Application No: AW/159/21/HH
Site Address: 25 The Drive Aldwick PO21 4DU
Description of works: Loft extension with 3 x rear dormers. This application affects the setting of the Craigwell House Conservation Area.

Thank you for your internet representation made on 23rd June 2021 which has been recorded as an objection with the comments as follows:

Drawing Title  
Proposed Plans & Elevations

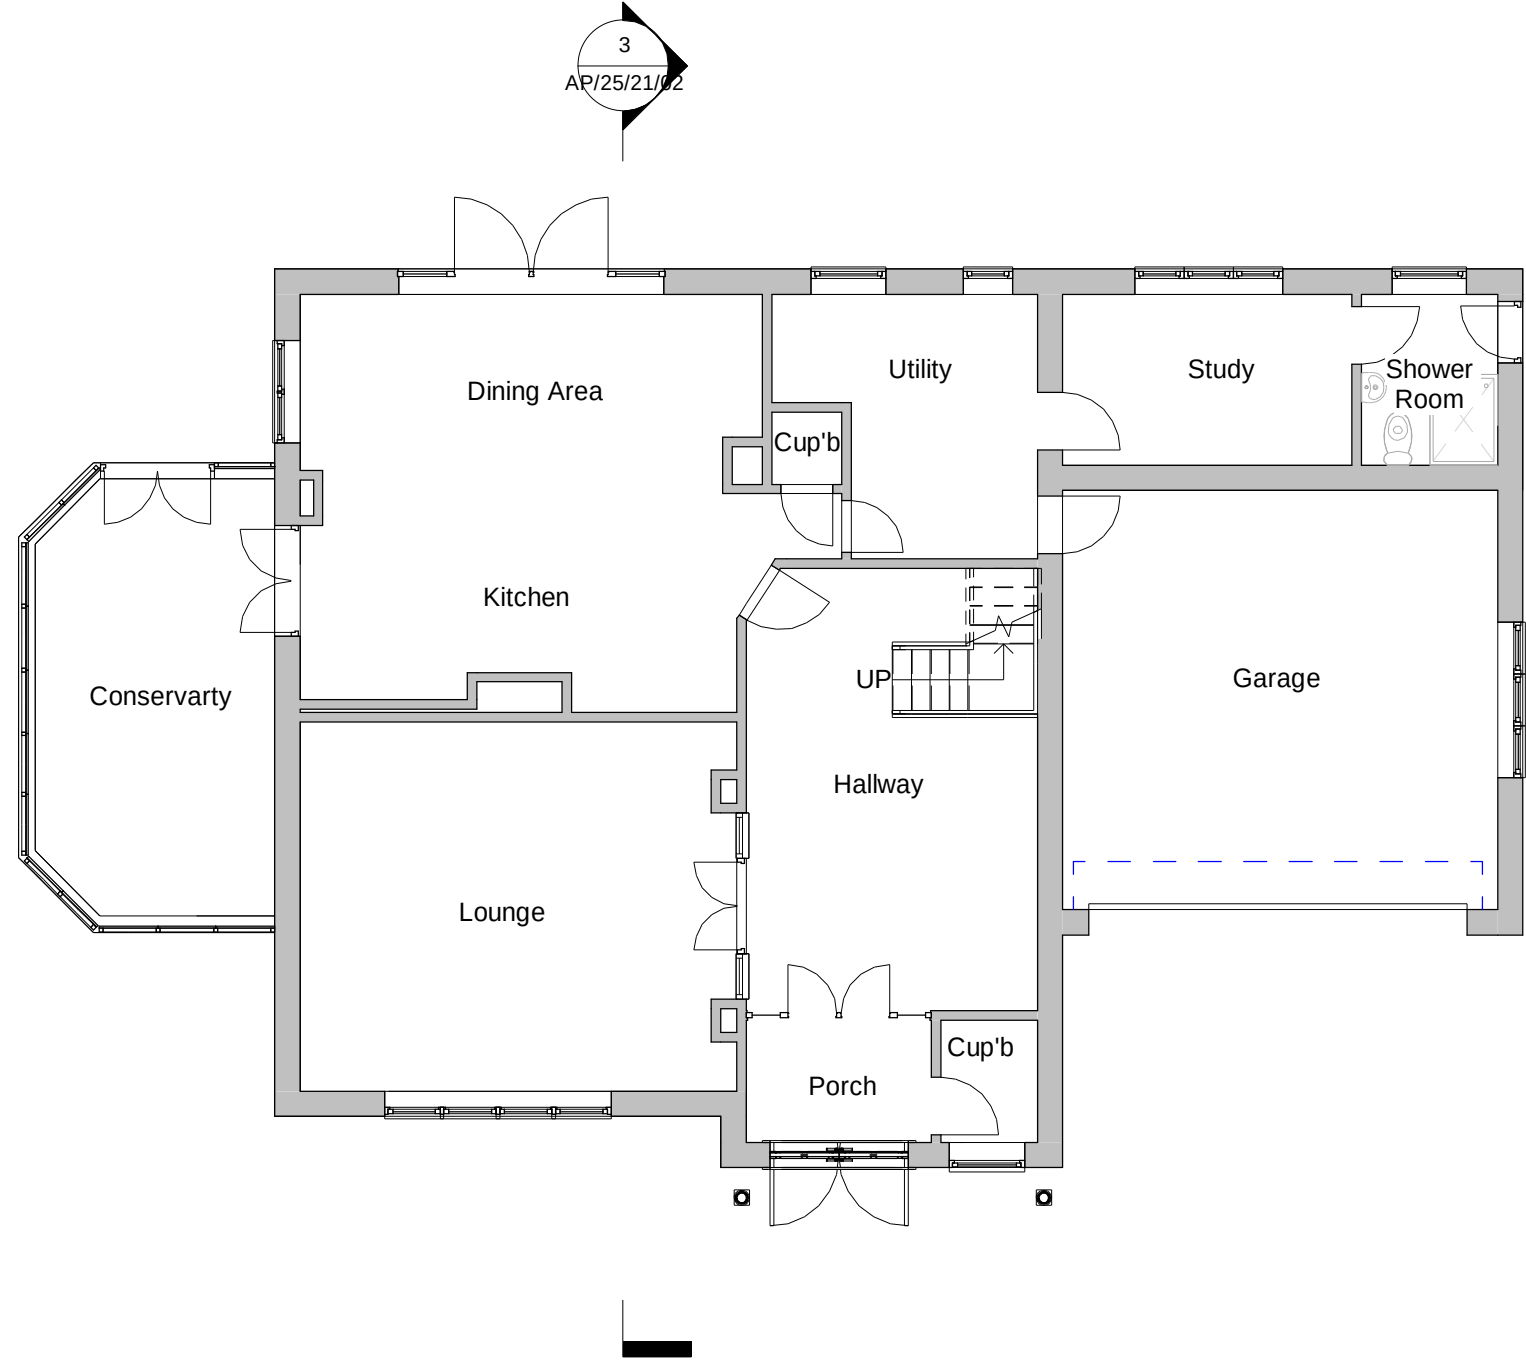
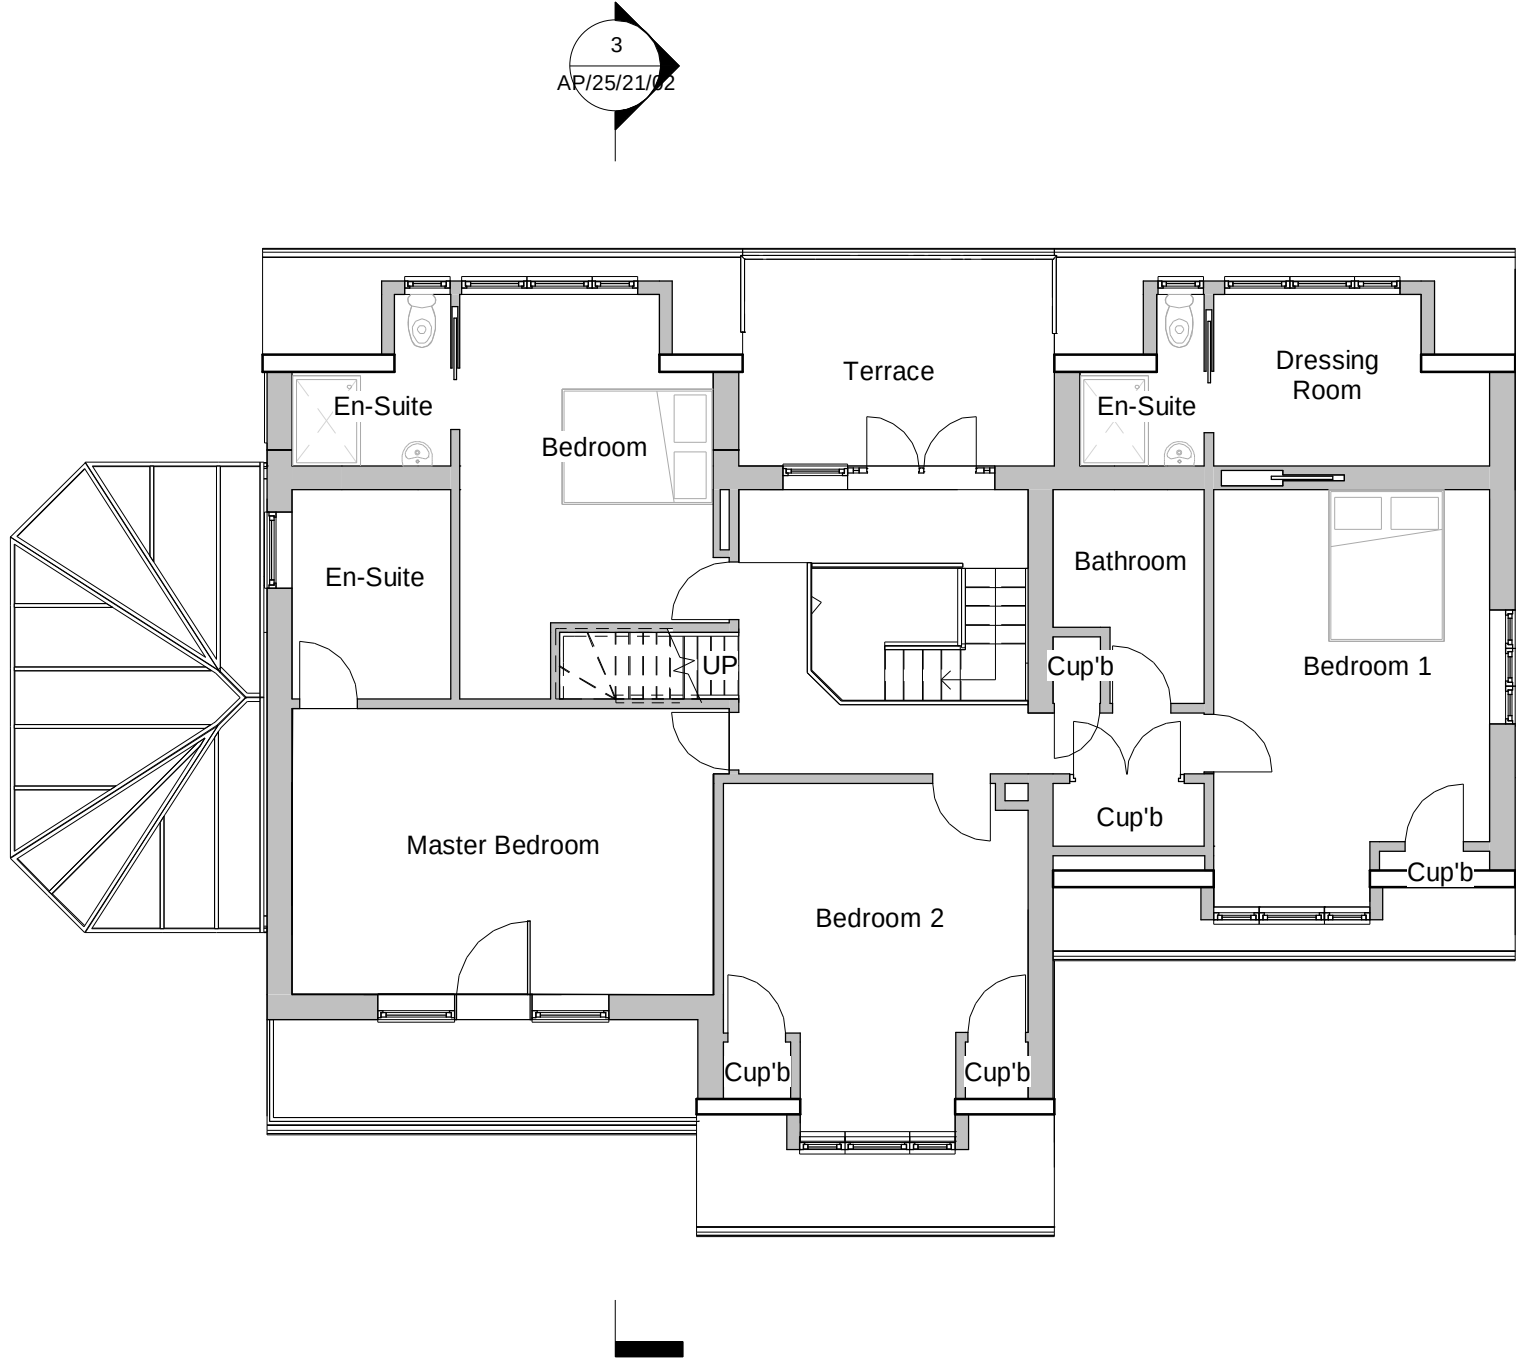
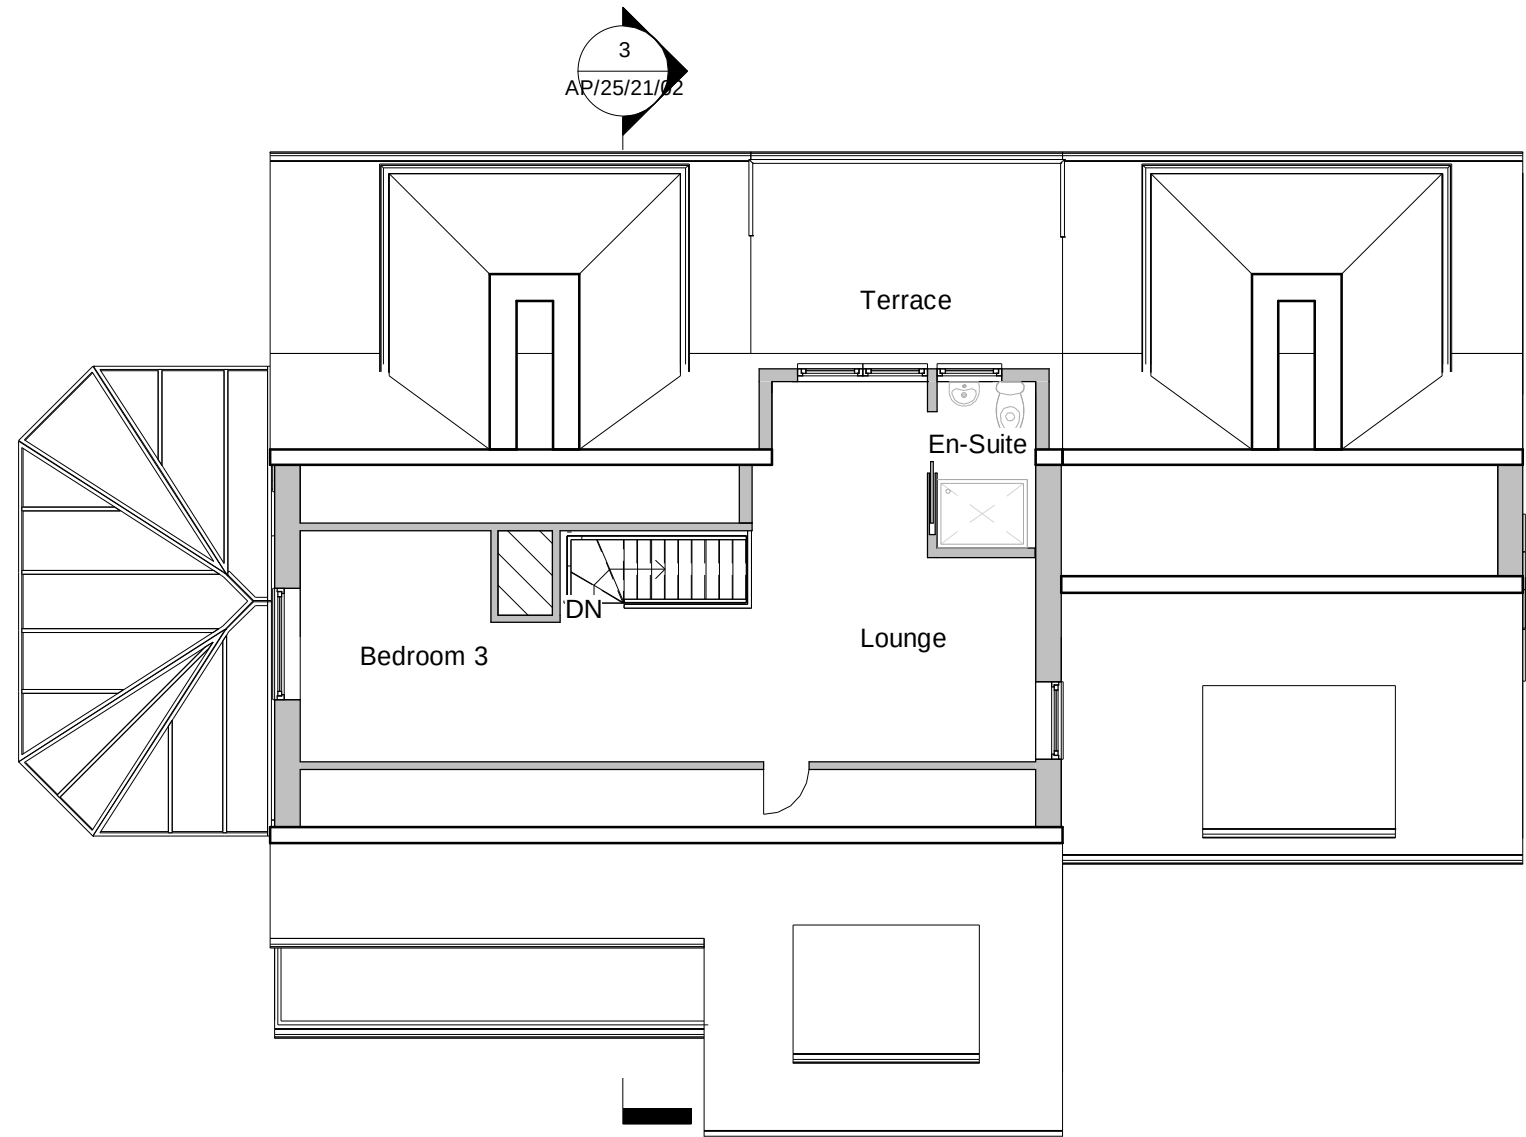
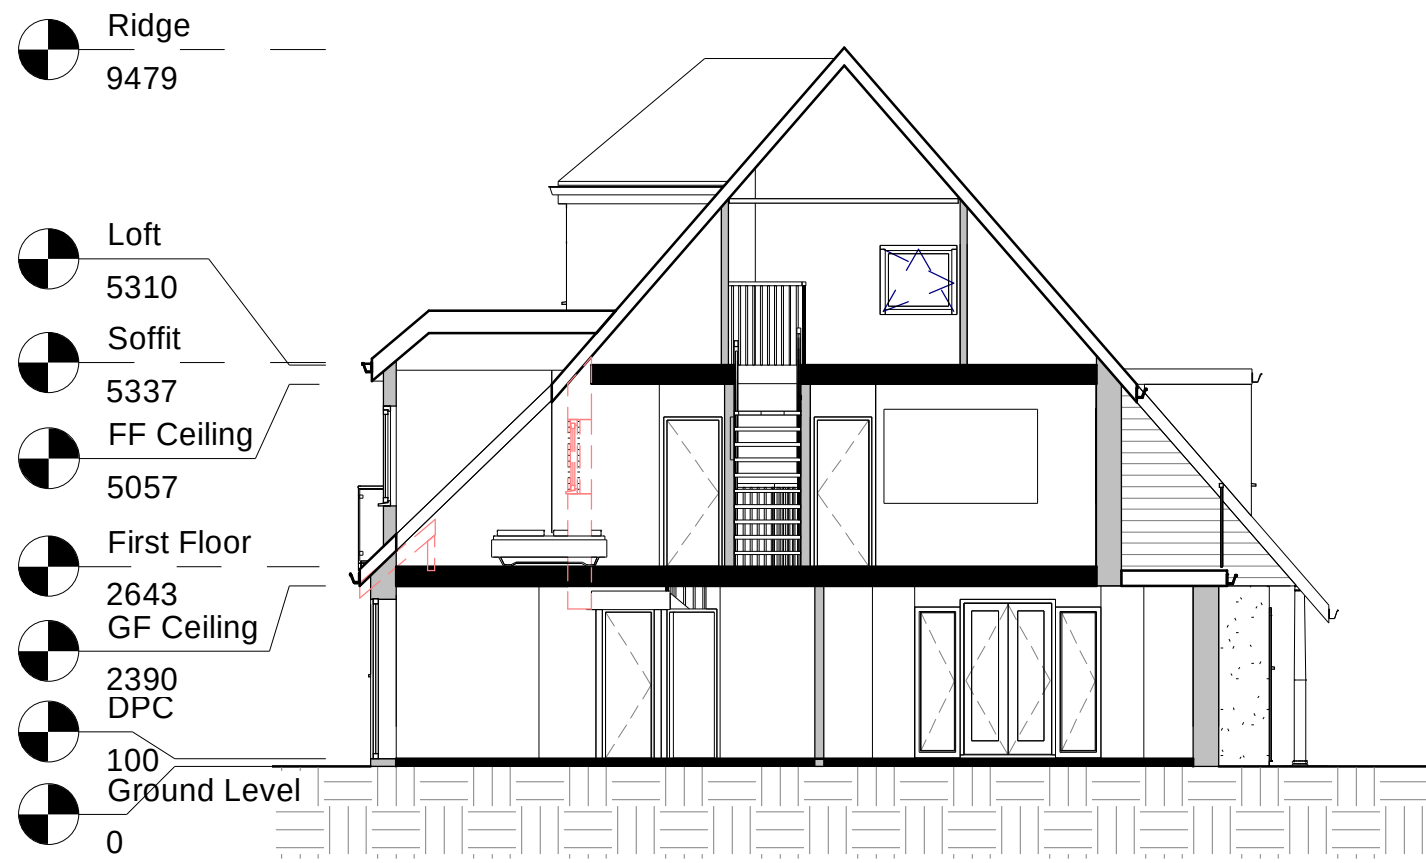
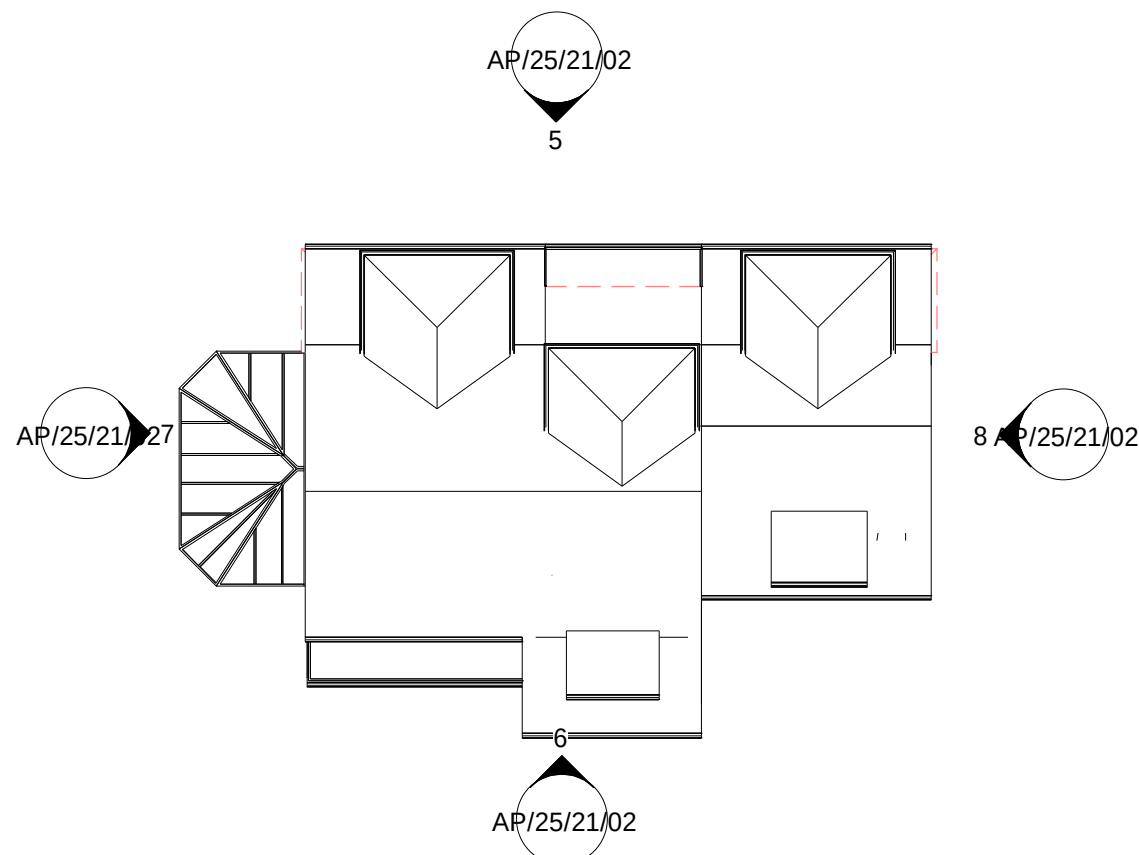
It is difficult to know exactly from the drawing submitted, but I estimate that the 1st floor window line will move approximately 2.2mtrs to the north, closer to my property.

As I previously commented I have reservations about the proposed extension on the first floor, but the use of dormer windows is over powering to the whole ambience of the area when this could be facilitated in another manner.

I object in the strongest possible manner to the proposed extension and use of a Dormer Window at loft level which will be both over powering but be a direct impact on our privacy and totally ruin the aesthetic outlook from our property.
